SSD-9237 – PROPOSED SOLAR FARM - YARRABEE SOLAR PARK, BACK MORUNDAH ROAD, MORUNDAH.

Roads and Maritime Services has reviewed the Environmental Impact Statement (EIS) and Traffic Impact Assessment (TIA) dated August 2018 prepared by SLR Consulting Australia for the Yarrabee Solar project. From the information provided it is understood that the proposal is for the establishment and operation of a 900 MW solar photovoltaic (PV) plant and associated infrastructure on the subject site. The subject site has frontage and access to Back Morundah Road, which is classed as a local road, within a 100 km/h speed zone.

Figure 21 Proposed Access Routes

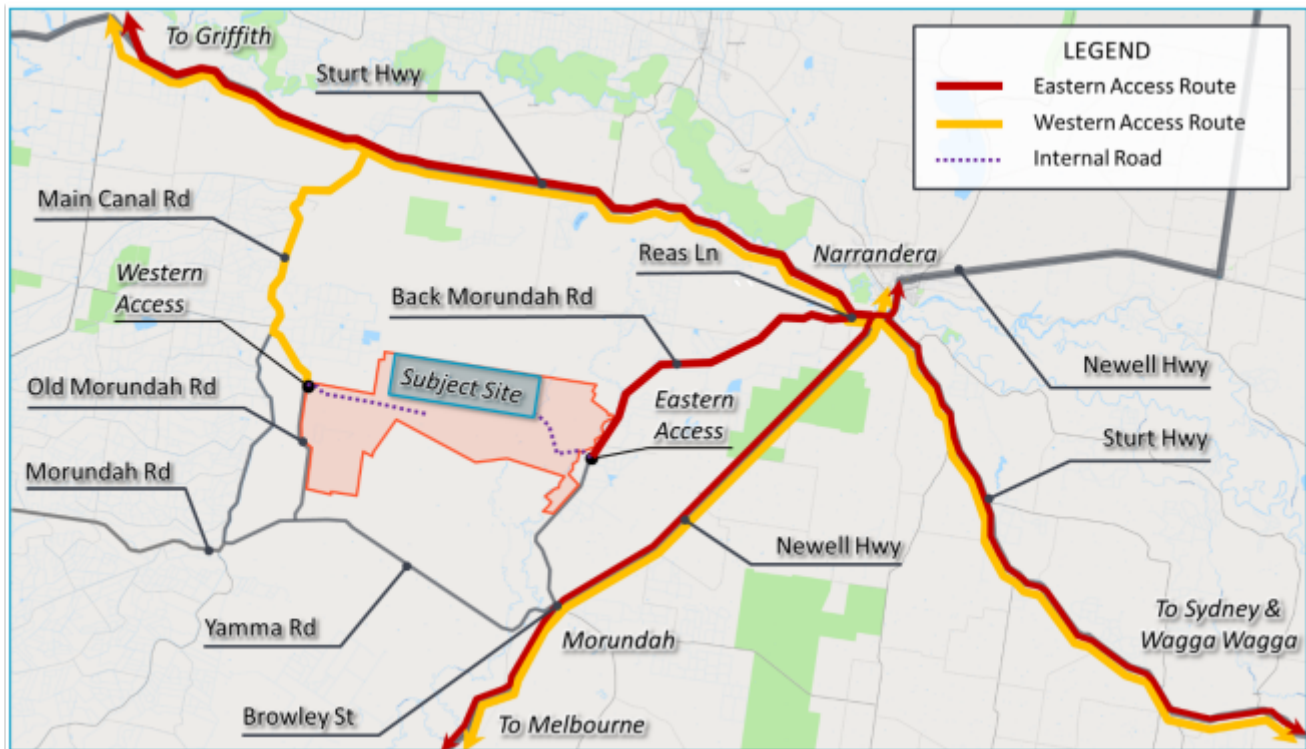
The EIS refers to an intended site access protocol to split light and heavy vehicles. The EIS indicates that the access plan is for heavy vehicles to enter and exit the site via the Western Access Route (via Main Canal Road) and for light vehicles and buses to access the site via the Eastern Access Route (via Back Morundah Road). Notwithstanding this EIS also refers to access for heavy vehicles via the intersection of the Sturt Highway with Back Morundah Road. Depending on the access route adopted the intersection of Main Canal Road or Back Morundah Road are proposed to be upgraded to provide an Auxiliary Left Turn - Short (AUL)(s) intersection treatment for left turn from the Sturt Highway in addition to the existing intersection treatment. The development is to be required to define the adopted access routes for light and heavy vehicles prior to the commencement of construction.

The submitted documentation does not finalise the preferred route for the delivery of components to the development site or the source of other products, such as the aggregate, water and sand. The submitted reports acknowledge that this development will require the preparation of an appropriate Traffic Management Plans. As the proposal relies on access via the classified and local road network this plan should be finalised in consultation with the relevant road authorities, in this case being both the Roads and Maritime Services and Council.

- i) Finalise details of haulage, including transport routes, volumes, vehicle type and length, timing, and frequency,
 - ii) Finalise details of any required road-specific mitigation measures.

- iii) Require that all vehicular access to the site be via the approved access route.

Figure B.10 Existing and SIDRA Assessed Intersection Layouts

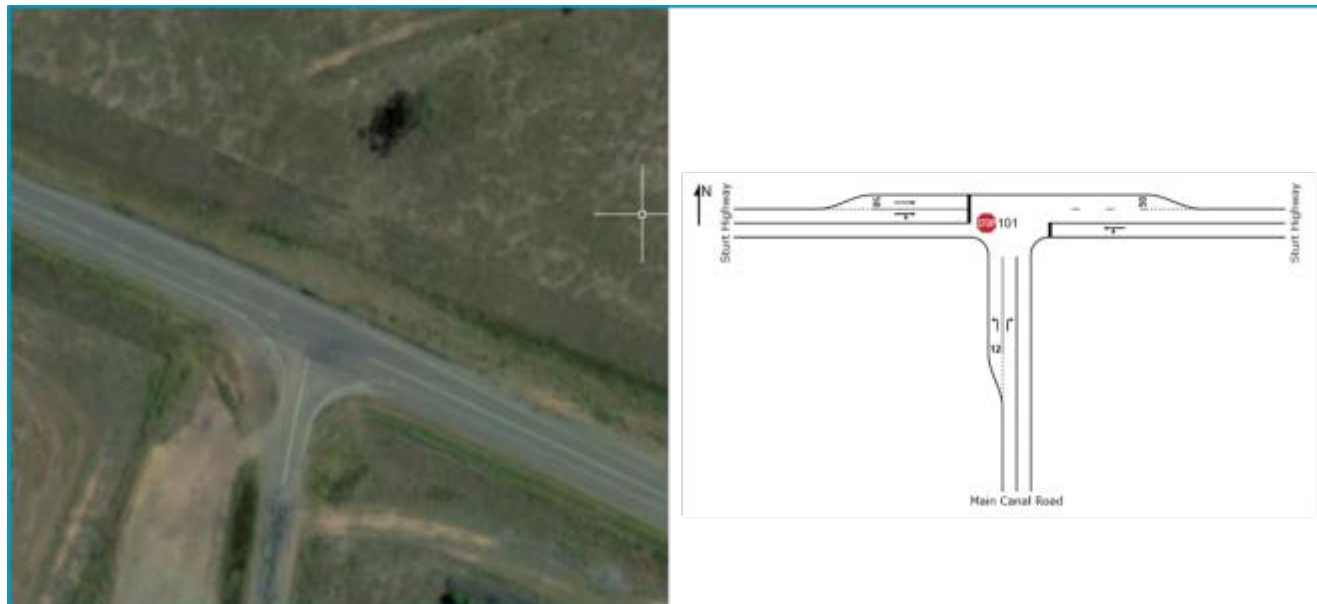
3. Subject to the adoption of the preferred route for access for heavy vehicles to the development site as a minimum the intersections of Main Canal Road or Reas Lane with the Sturt Highway shall be constructed and the roadside maintained to provide the following:

- b) Be constructed to provide an Auxiliary Left Turn - Short (AUL)(s) intersection treatment on the Sturt Highway in accordance with the Austroads Guide to Road Design as amended by the supplements adopted by Roads and Maritime Services for the posted speed limit. The intersection is to be constructed to the standards required for an approved road train route. Details certifying the construction of the intersection to the required standard shall be provided to Roads and Maritime Services.

- c) The construction of the local road intersection with the Sturt Highway to provide for 2 travel lanes and be sealed for at least 50 metres from its intersection with the Highway. The intersection shall be designed and constructed so that vehicles turning between the Sturt Highway and local road are not required to cross to the opposing travel lane in order to perform a turn manoeuvre. The intersection shall be line marked in accordance with Australian standards.

- e) Provide a new polymer modified asphalt heavy duty pavement wearing surface across the intersection to accommodate the heavy vehicle turn paths to and from the Sturt Highway.
